From: Michael Eastham <Michael.Eastham@arun.gov.uk>
Sent: 03 April 2020 15:58
To: Planning.Responses <Planning.Responses@arun.gov.uk>
Subject: FW: BN/85/19/DOC - The Lillies

Subject: RE: BN/85/19/DOC - The Lillies

I have received the email below from the applicant for BN/85/19/DOC at the Lillies, Yapton Road in Barnham.

Comments on proposals;

## TYPICAL MANHOLE DETAIL TYPE B

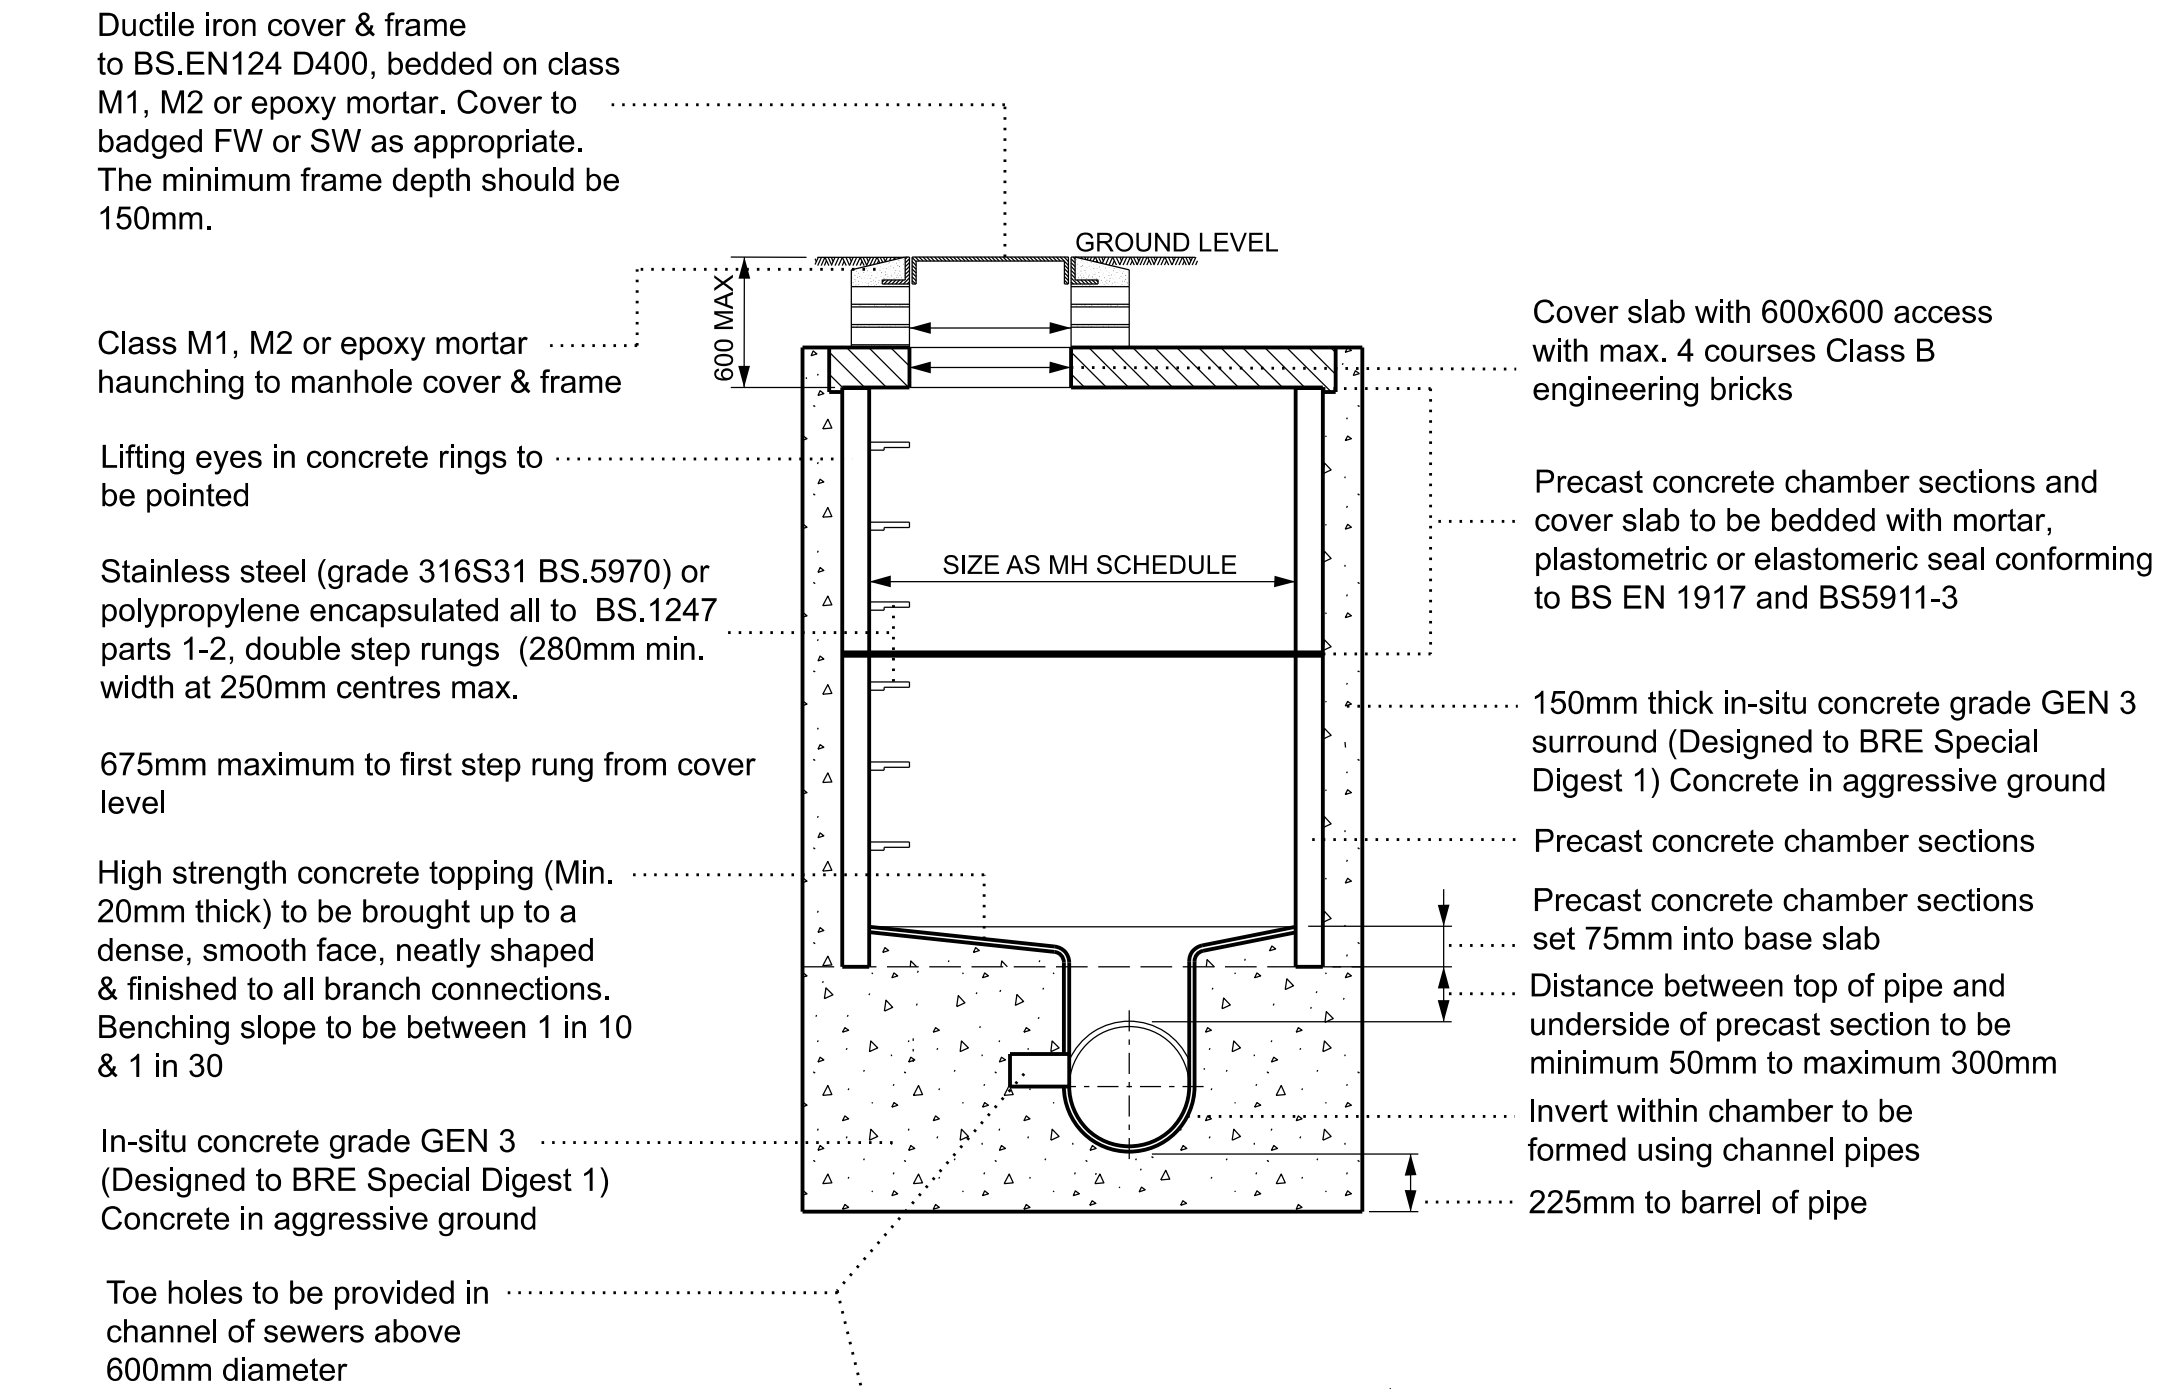
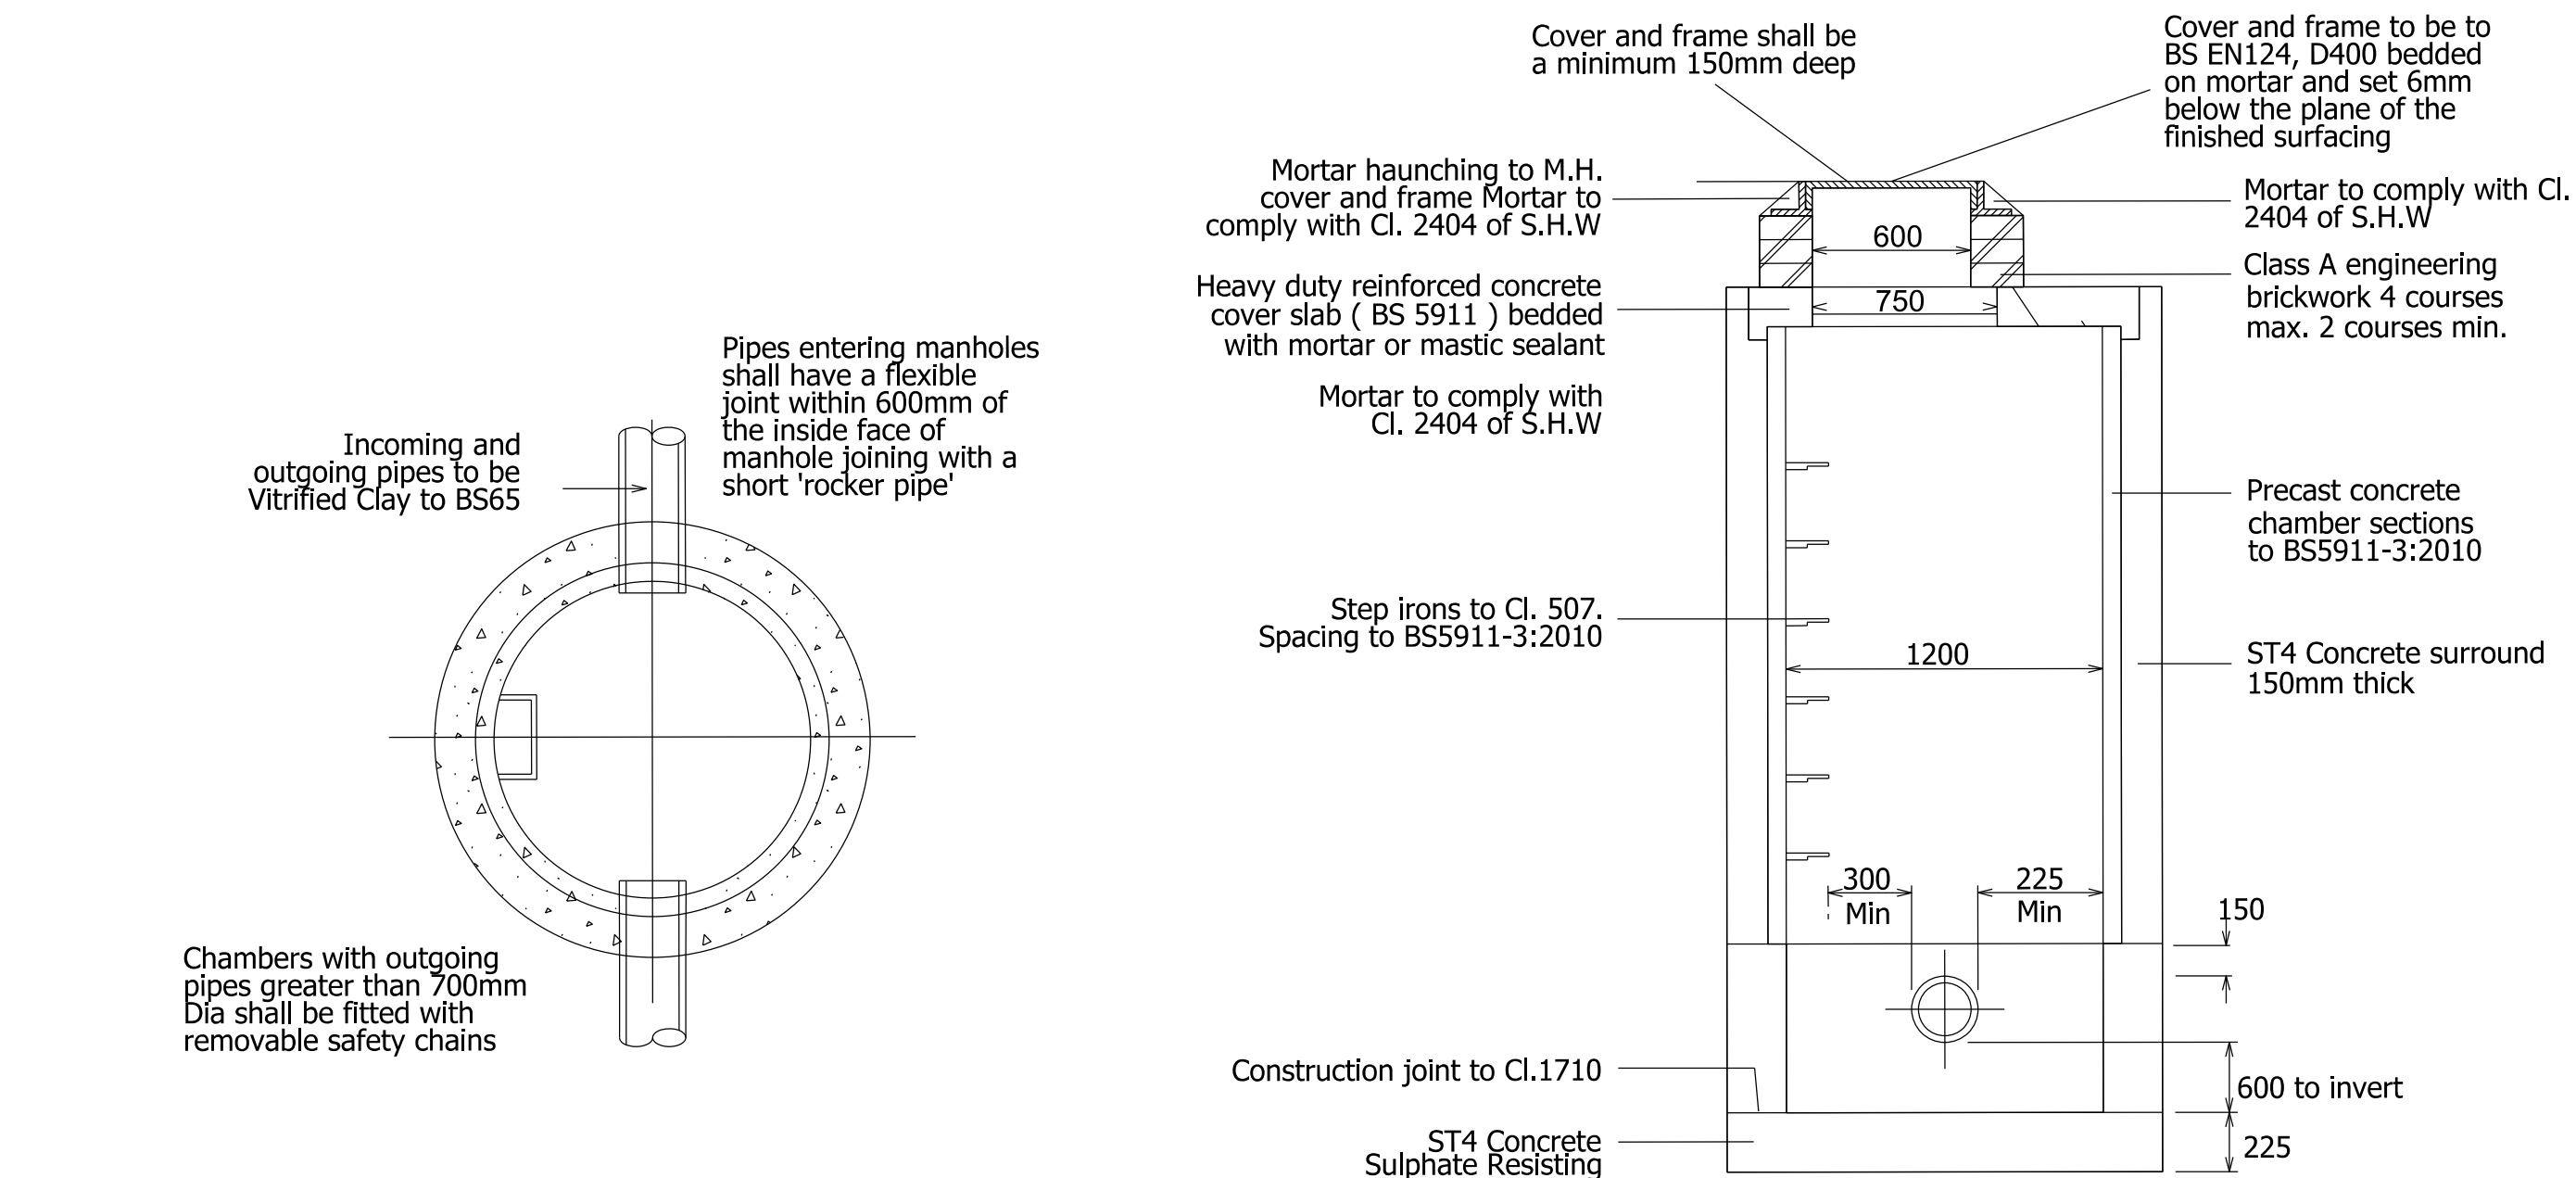
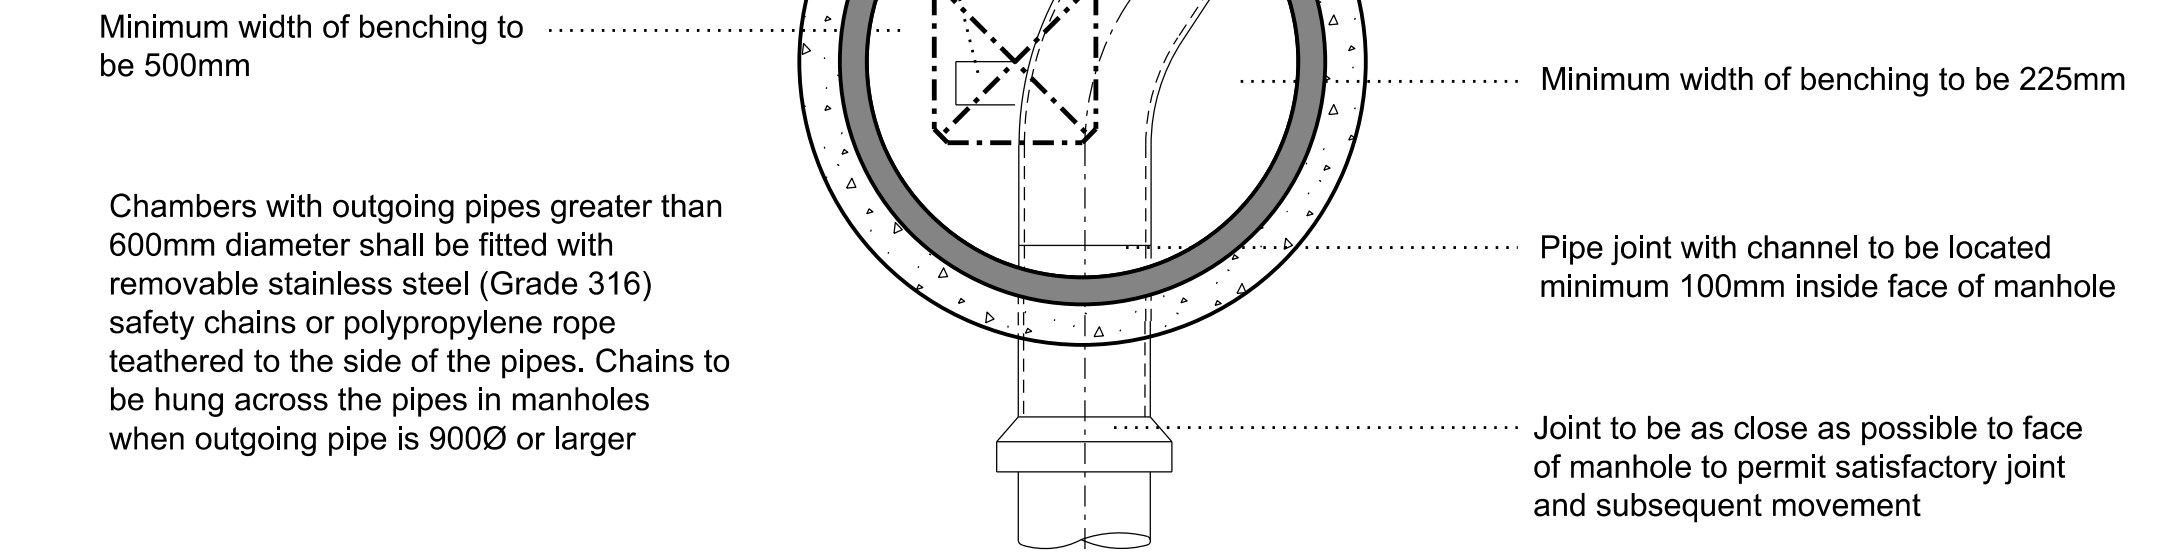
14. Add note 'All pipes to be connected at soffit to soffit level'. *Added*
15. Provide manhole construction details for all manholes in the highway. *Drawing included*

## CLASS S BEDDING DETAIL

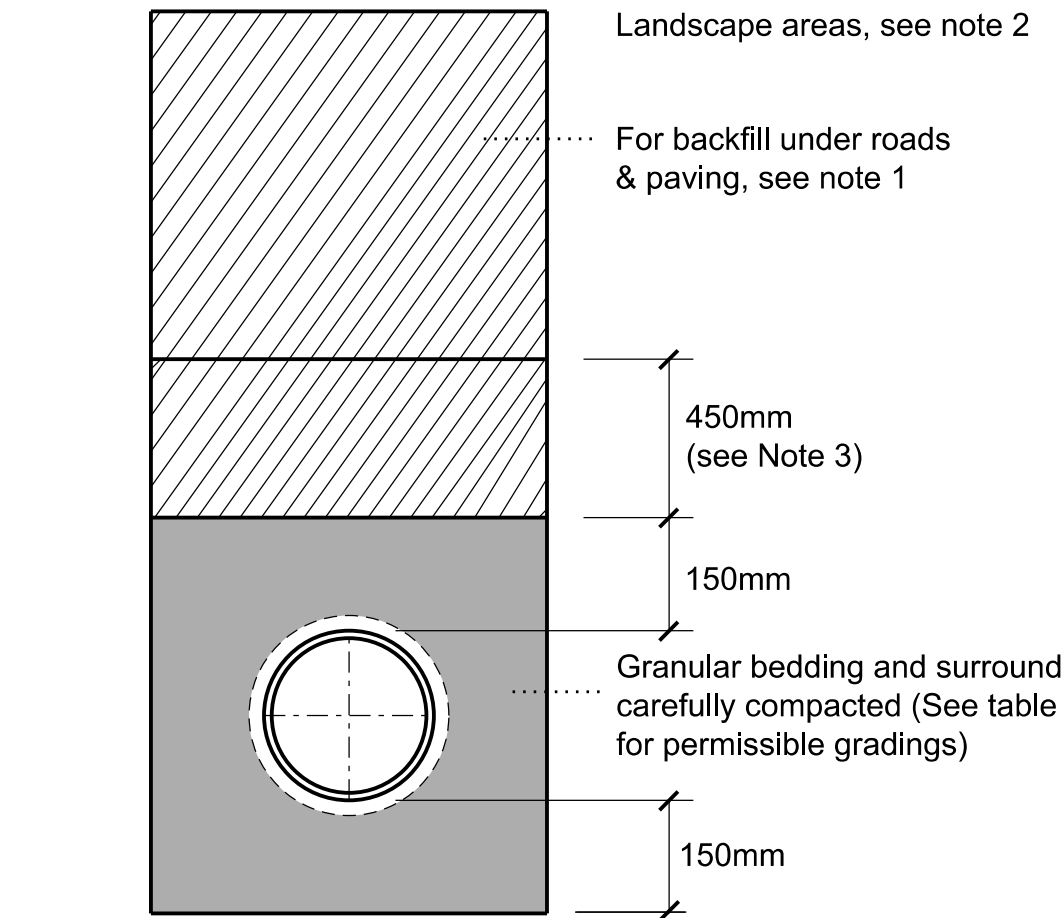
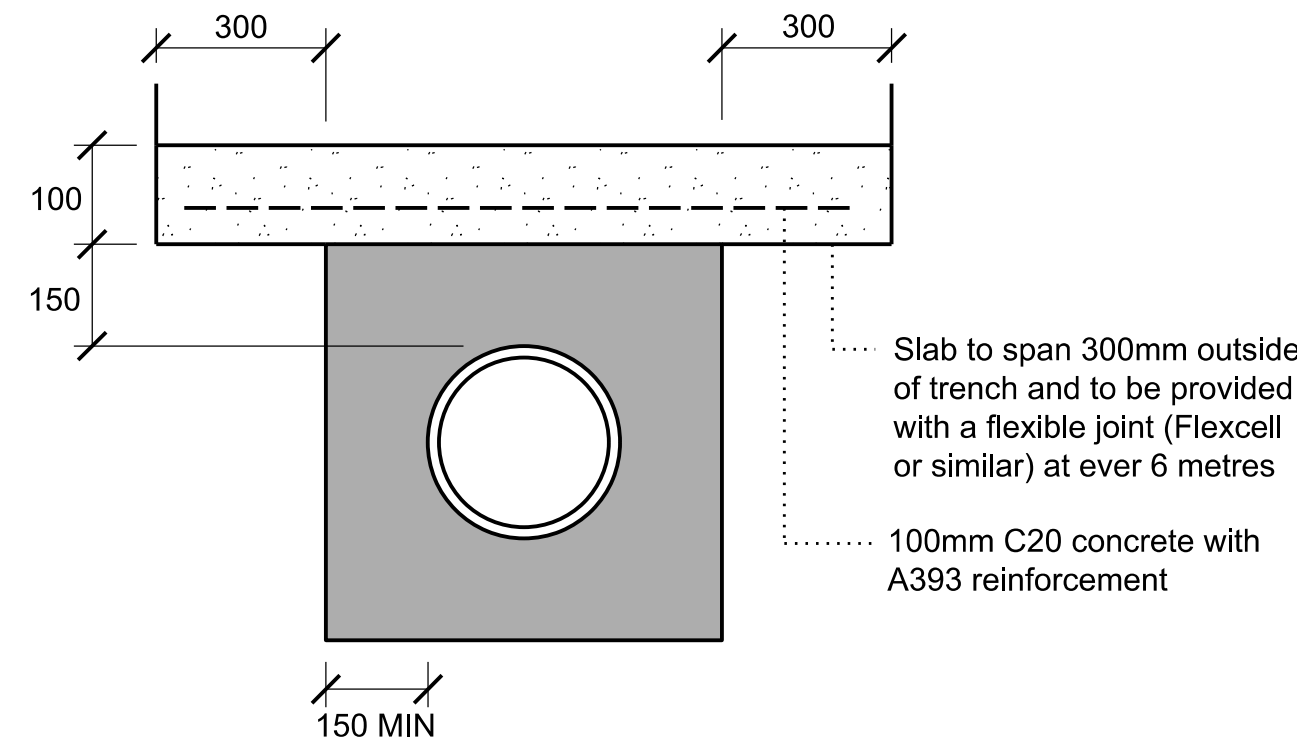
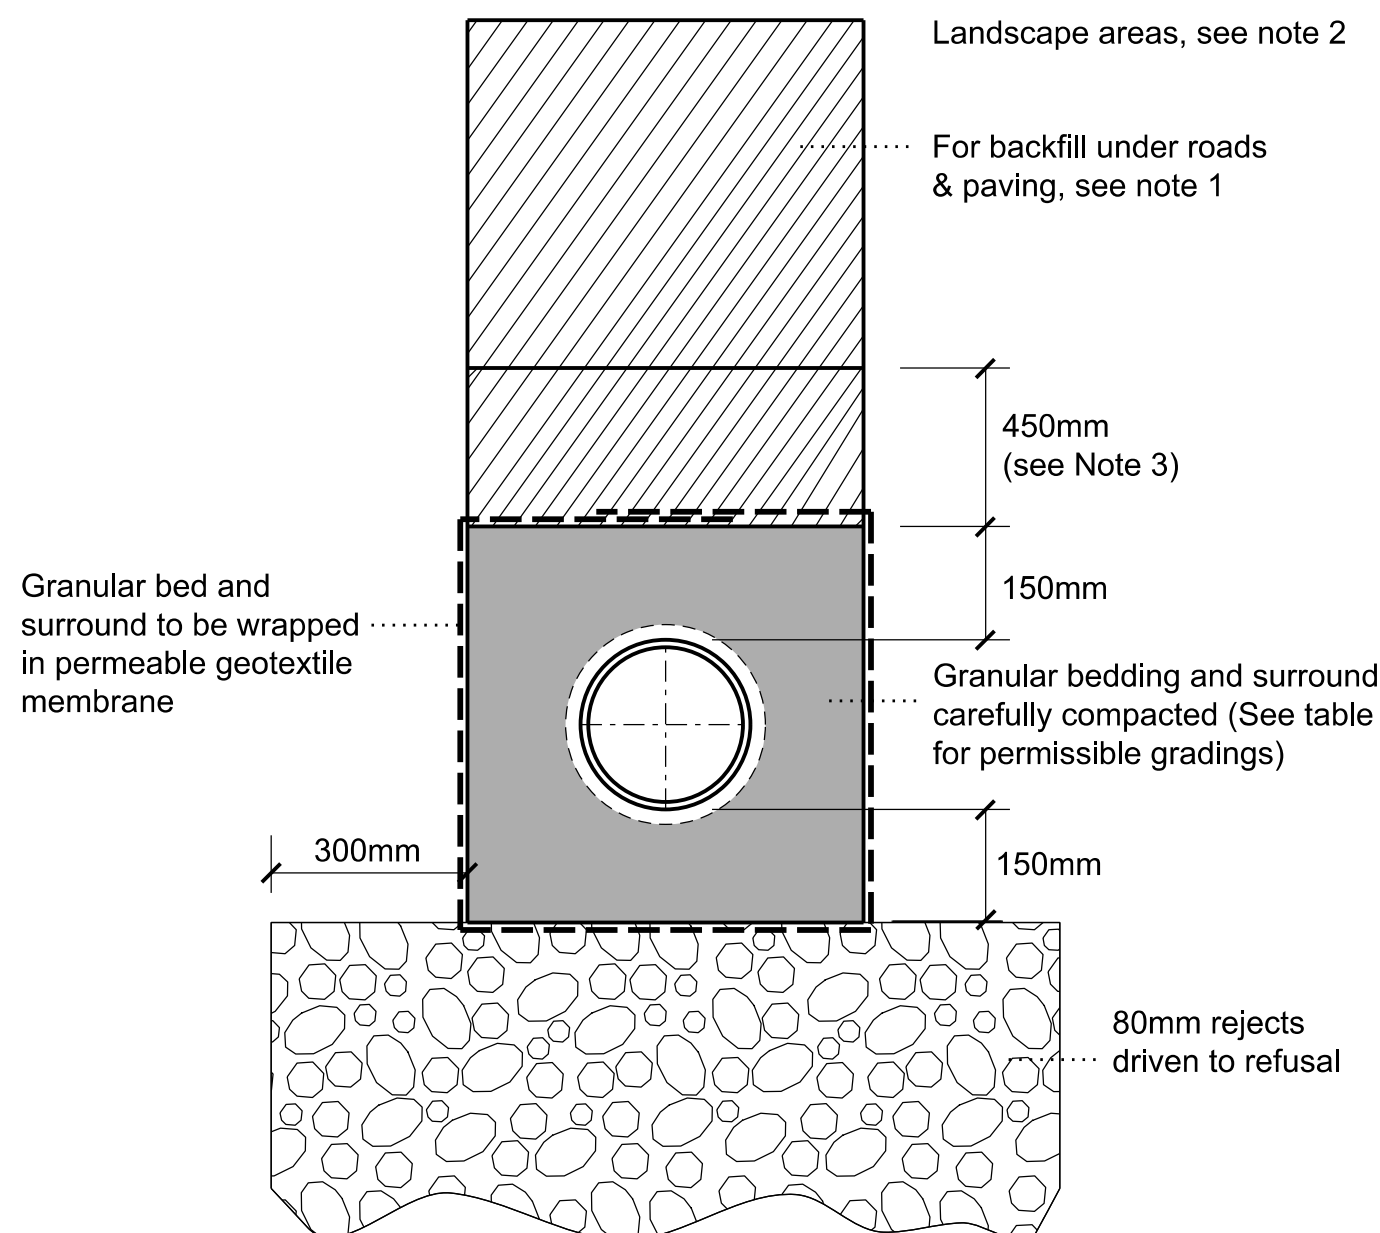
16. Provide pipe bedding details ie. class S and class Z. *Drawing included*
